From: Anna Gillings [REDACTED]
Sent: 16 July 2018 10:58
To: Juan Baeza
Cc: Timothy Bloomfield; Sam Rous; Emma Patchell
Subject: RE: A/23/18/DOC - Broadlees, Dappers Lane, Angmering

I refer to the trail of emails below regarding an application for the approval of details reserved by condition at the site of Broadlees, Dappers Lane (A/23/18/DOC). Unfortunately, despite several emails and voice messages to the Planning Officer, Timothy Bloomfield, we have been unable to enter into any helpful discussions. As you can appreciate this is very frustrating for my client especially given the amount of time the conditions have been submitted. I therefore write to you, as the Group Head of Planning – however if my query would be more appropriate directed elsewhere, I would be grateful if you could advise.

Details in relation to condition 7 (Construction Management Plan) and 19 (Tree Protection Measures) were originally submitted in February 2018 with later details provided in April 2018. I am also concerned by the way condition 19 has been interpreted thus far (by the Planning Officer and the Arboriculturalist) and would appreciate a discussion regarding this matter. It is my understanding

TREE PROTECTION (Plan 3A)

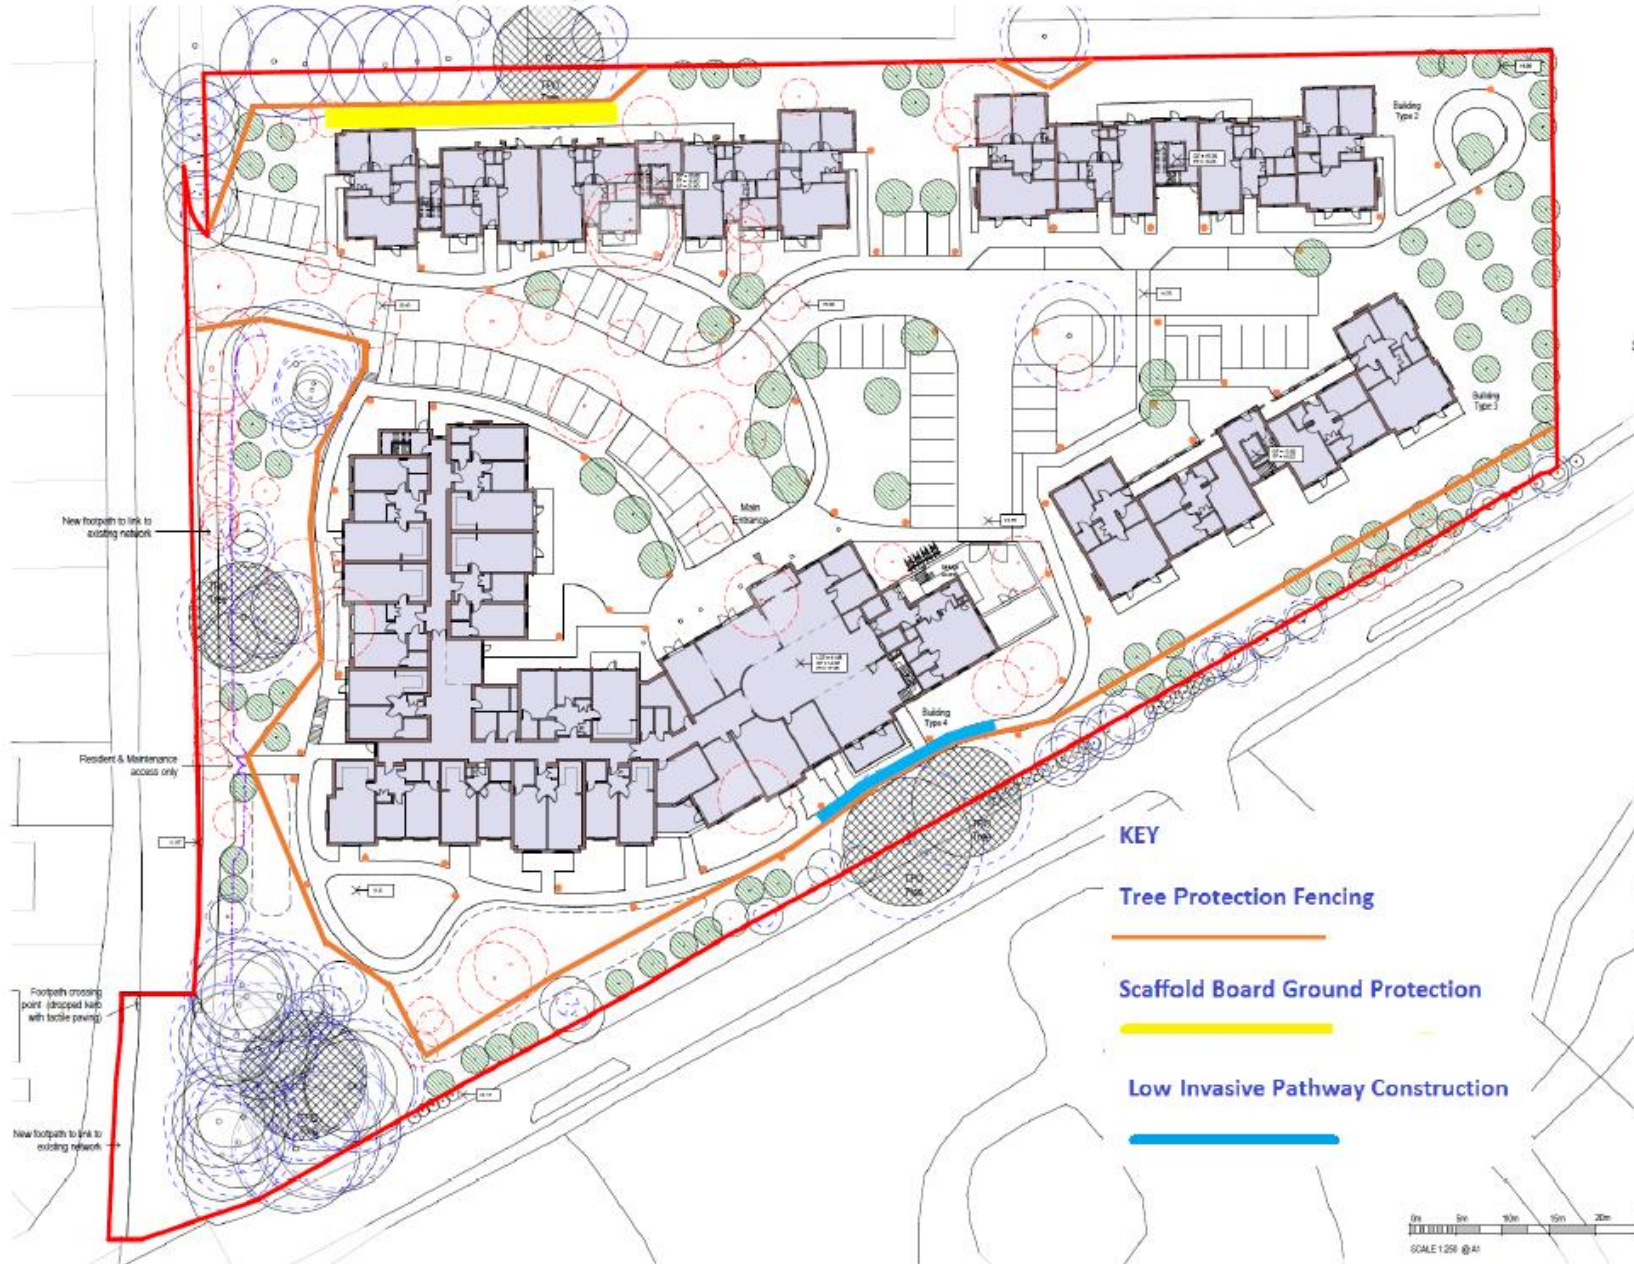
I note that the applicant has submitted a Tree Protection Plan Ref: Plan 3A – the measures set out on this plan are acceptable but will need to be implemented and then a Pre-Commencement Meeting can take place [at a mutually convenient time] between the applicants representative and the Arun DC Tree Officer to agree that the Protective Fencing complies with BS5837 recommendations and is 'Fit For Purpose' and that it has been erected exactly as shown on Plan 3A".
